**BOLTON-BY-BOWLAND, GISBURN FOREST & SAWLEY
PARISH COUNCIL**

PLANNING APPLICATION NO:..... 0191.....

RELATING TO..... Stocks House, Bolton-by-Bowland.....

Application 3/2013/0191

PROPOSED SIDE ELEVATION

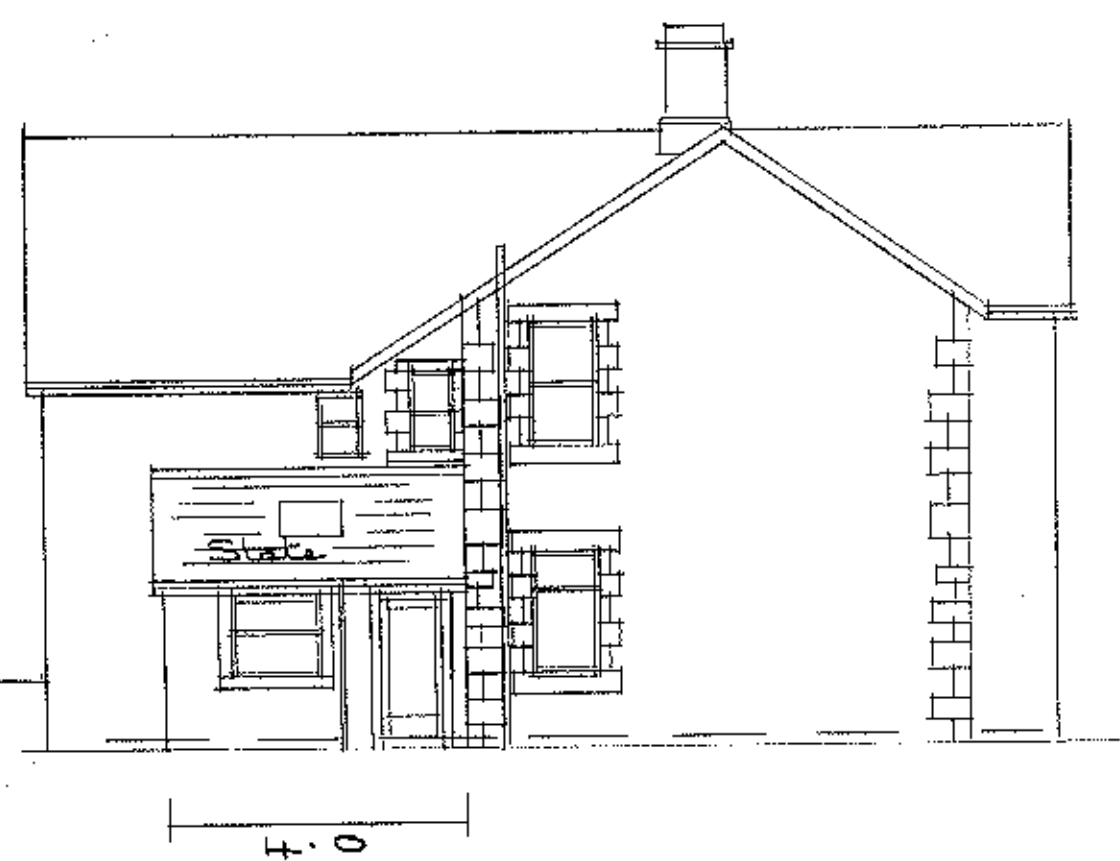
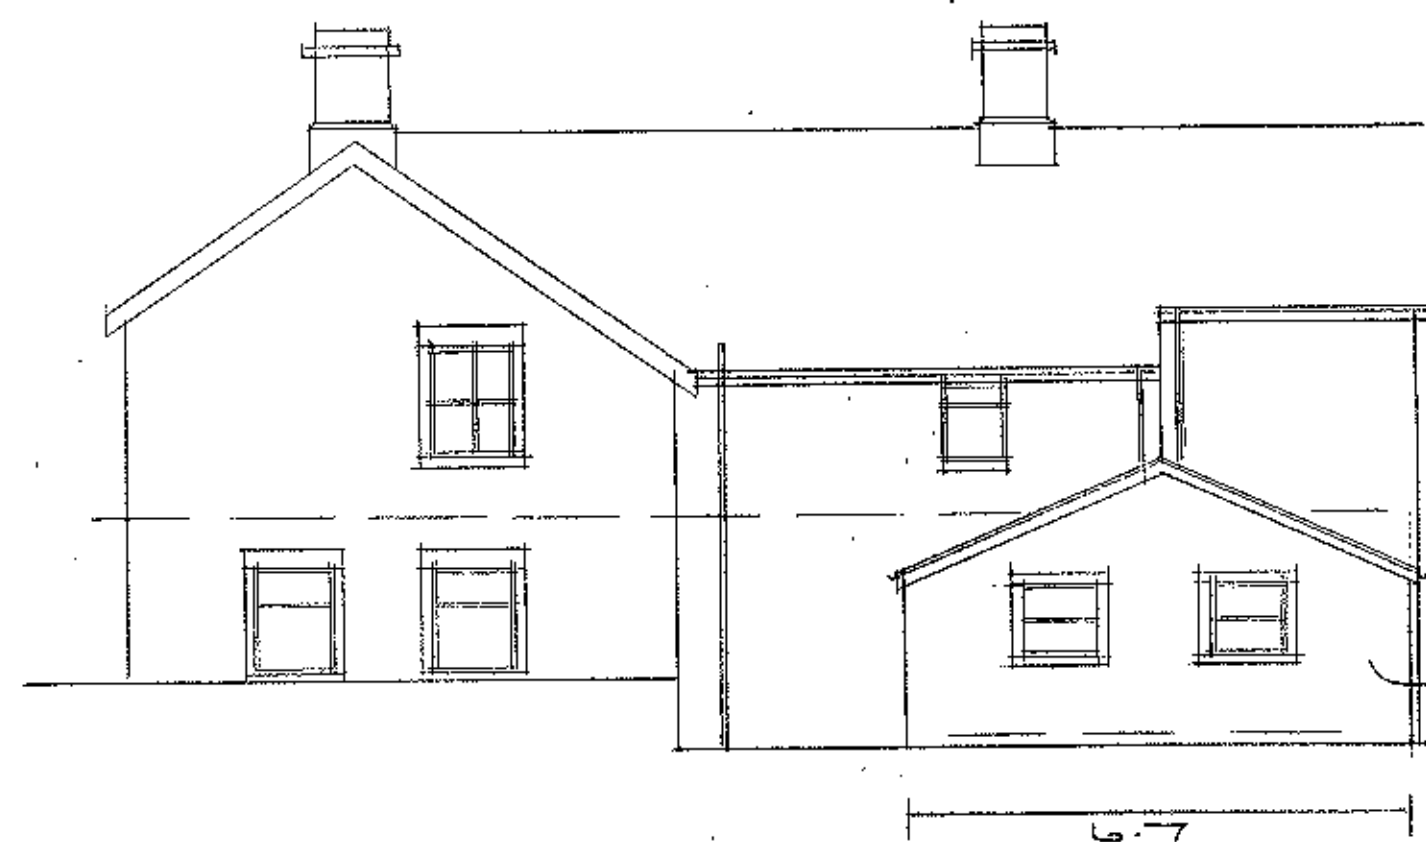
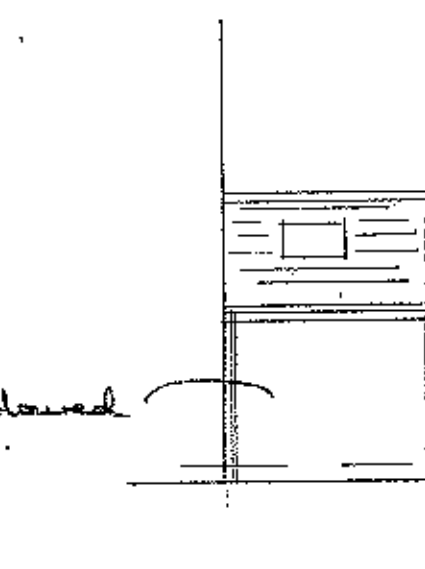
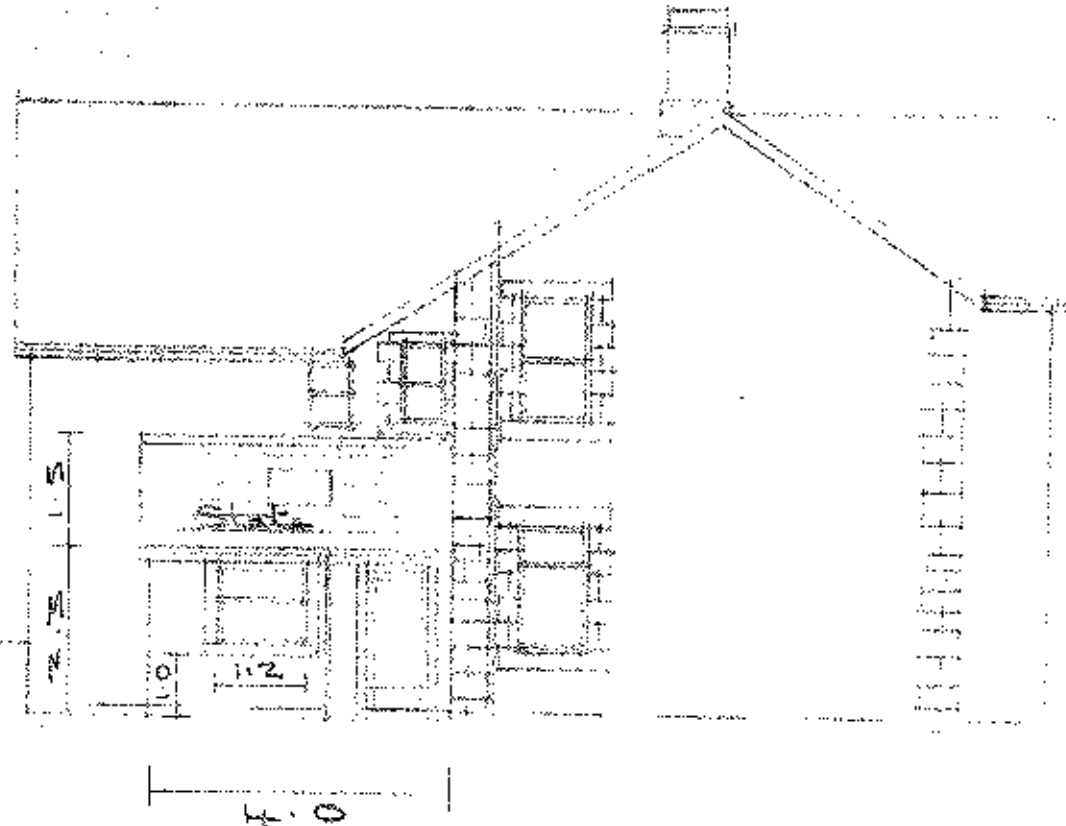
The Parish Council have no objections to the extension. However, whilst we have no objections to the rear and side being rendered, we do feel that the elevation in line with the gable end of the property should be in coursed limestone to match the existing.
